Recommendation Report for Planning Permission for Works or Extension to a Dwelling

REF NO: FP/64/22/HH

LOCATION: 12 Courtlands Way
Felpham
PO22 6AW

PROPOSAL: Erection of single storey pitch roof rear extension and replacement carport roof.

Title
Elevations as Proposed

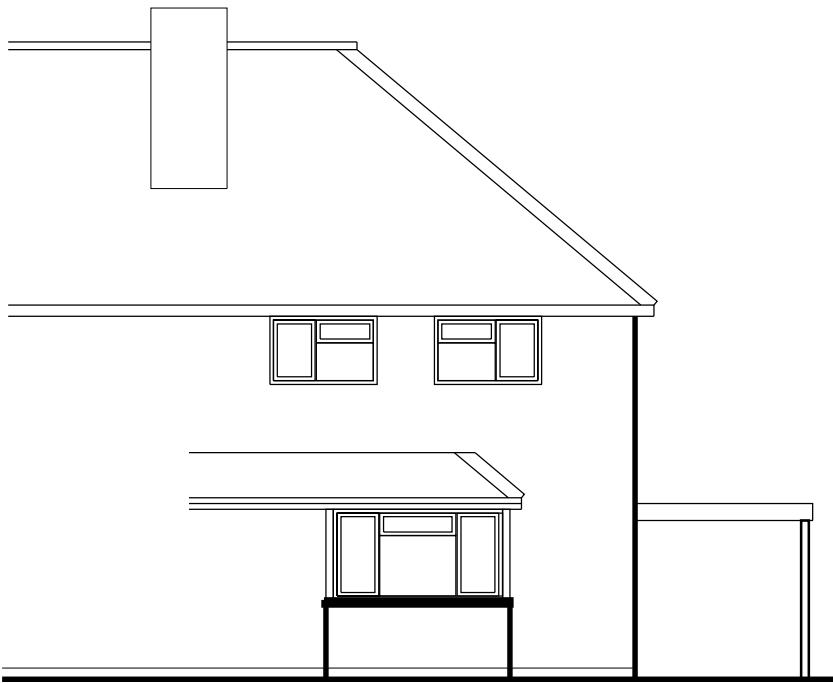
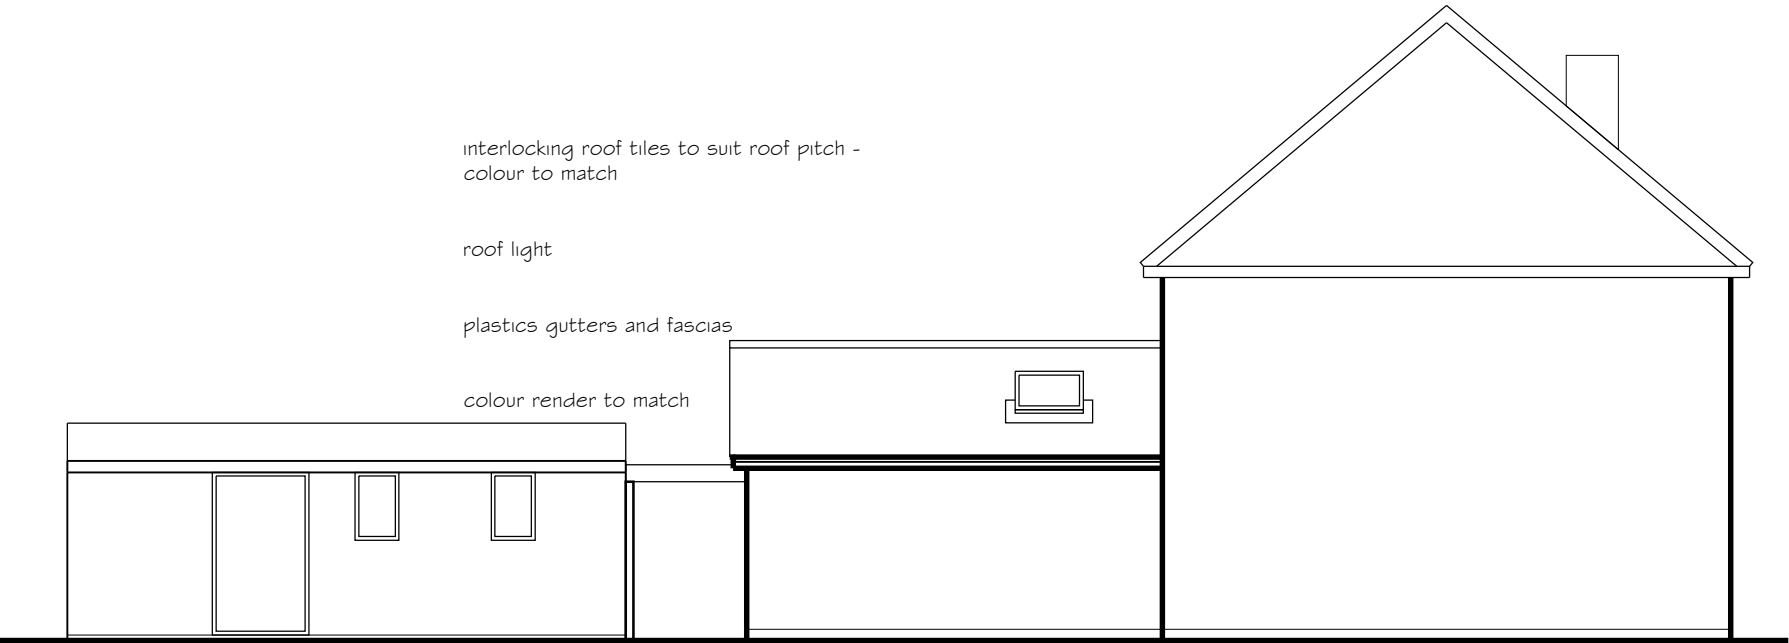
The rear extension is to be approx. 5.6m in depth, 5.8m in width with a ridge height of 4m and eaves at 2.4m. The scale of this rear extension is moderate relative to the host dwelling and remains visually subservient. Additionally, it is to be constructed from materials that match the host dwelling. The pitched roof design is acceptable, and it features 1 No. rooflight to the South side of the roof which is also acceptable.

The car port is to be approx. 7.3m in depth, 2.3/3.1m in width and 2.3m in height, sited in front of the garage and running up the northern (side) site boundary to the rear elevation of the dwelling. The scale and siting of this car port is acceptable. Although it is set back from the front of the property, it would be visible from the street. It is to consist of timber posts and a translucent roof, these materials are acceptable. Given its scale, siting, and design, it will have minimal views from the street and it will not give rise to any adverse visual impact on the wider street scene.

The proposed car port runs along the northern side site boundary at a height of 2.3m. The scale of the car port frame and its low height means it will not give rise to any significant impacts by way of overbearing or overshadowing on the North neighbour dwelling (No. 10 Courtlands Way).

Title
Plans as Proposed

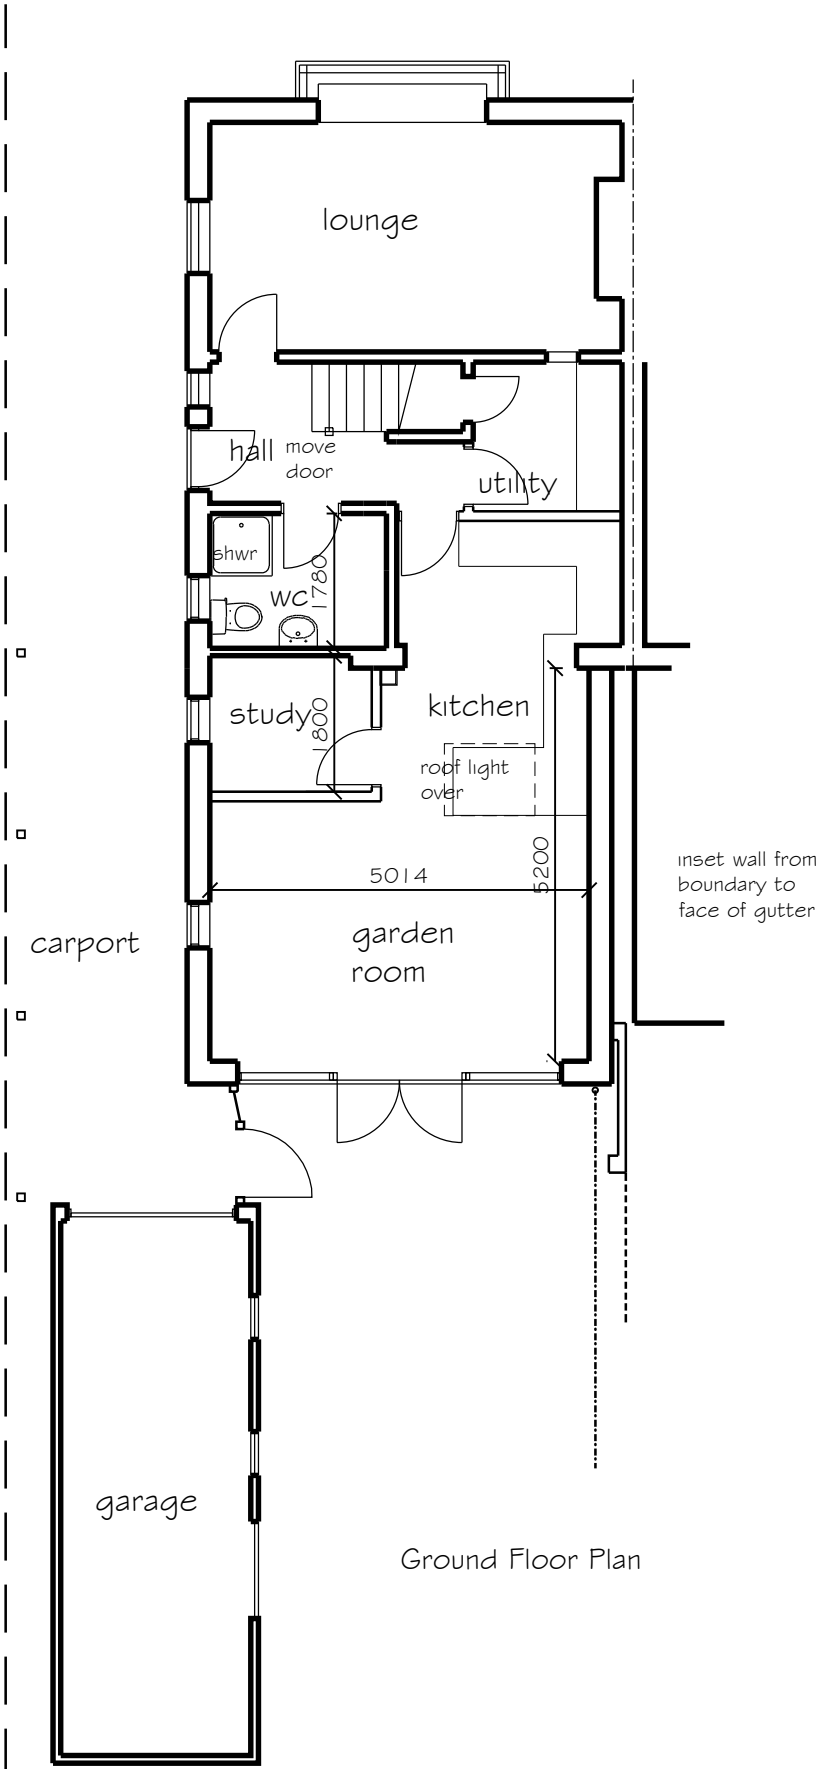
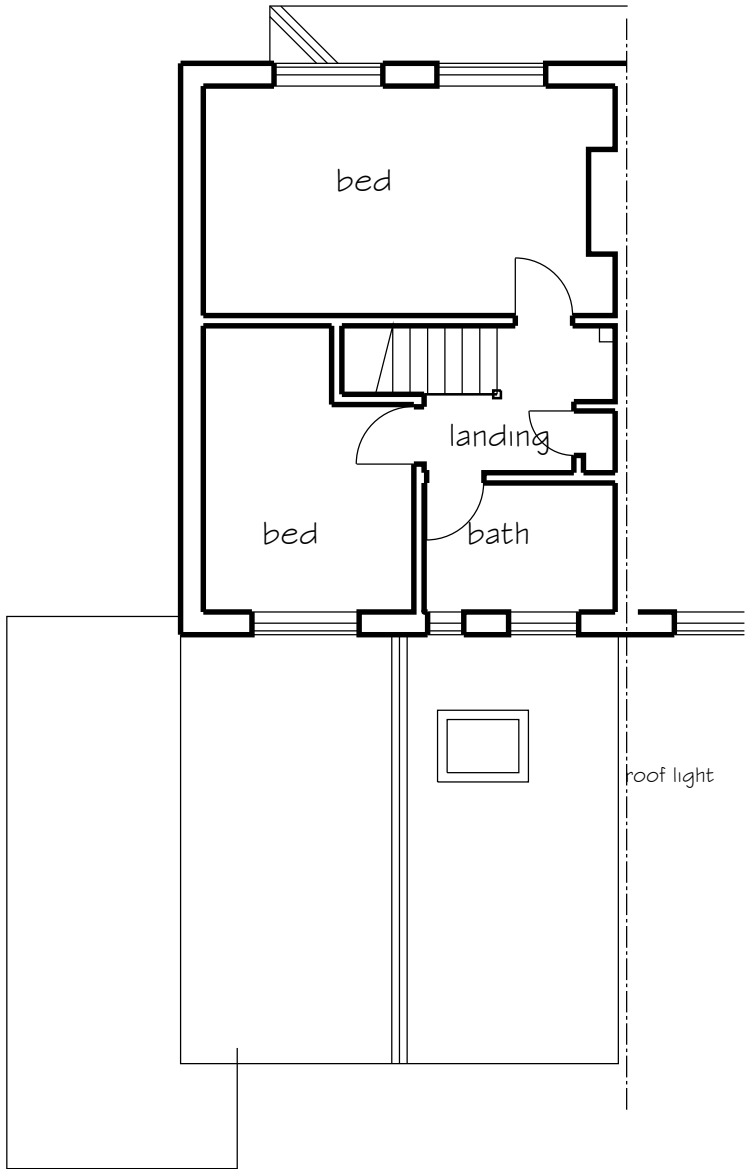
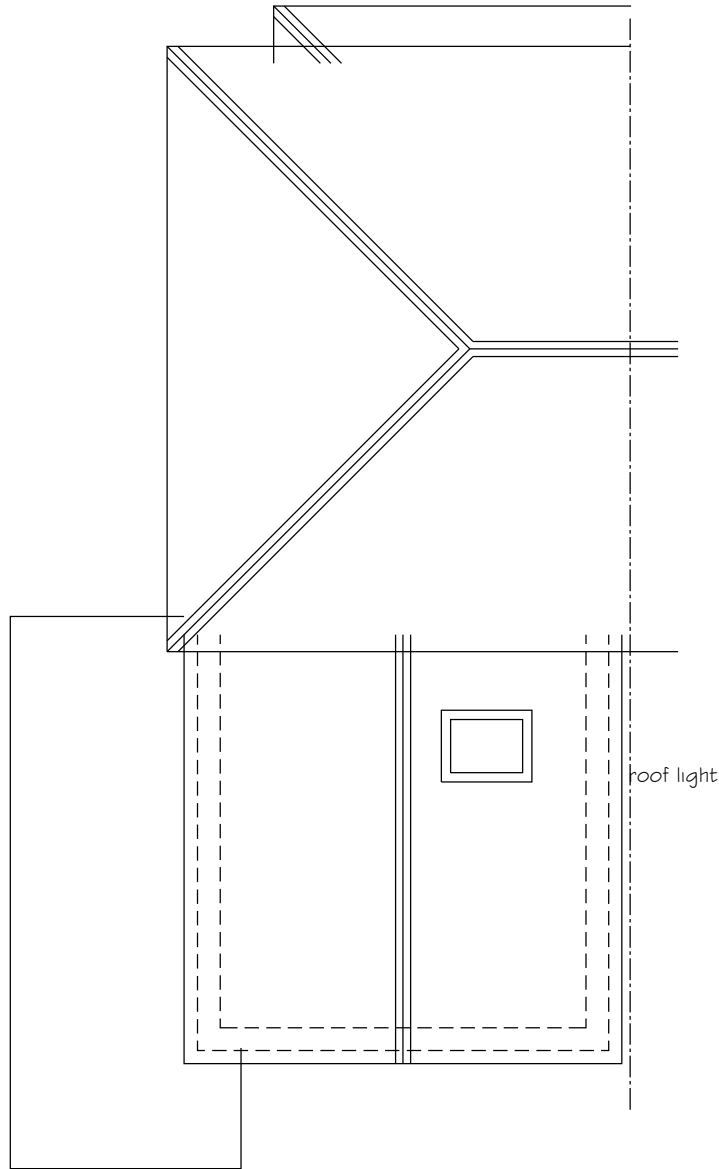
The proposed rear extension meets the southern site boundary. The southern neighbour dwelling (No. 14 Courtlands Way) features a rear extension. Owing to the neighbouring rear extension positioning the rear ground floor viewpoints further to the rear of the property, the proposed rear extension does not intersect neighbouring rear 60-degree sightlines. Additionally, owing to the low eaves height of the extension there is no intersection of 45-degree light accessibility lines from the rear viewpoints of any neighbour dwellings. As such, the extension gives no rise to any adverse impacts by way of overbearing or overshadowing on any neighbour dwellings.

The proposed extension includes 2 No. North facing windows and 2 No. windows and glass doors to the rear of the extension. These new viewpoints are at ground floor level and do not give rise to any adverse impacts by way of overlooking.
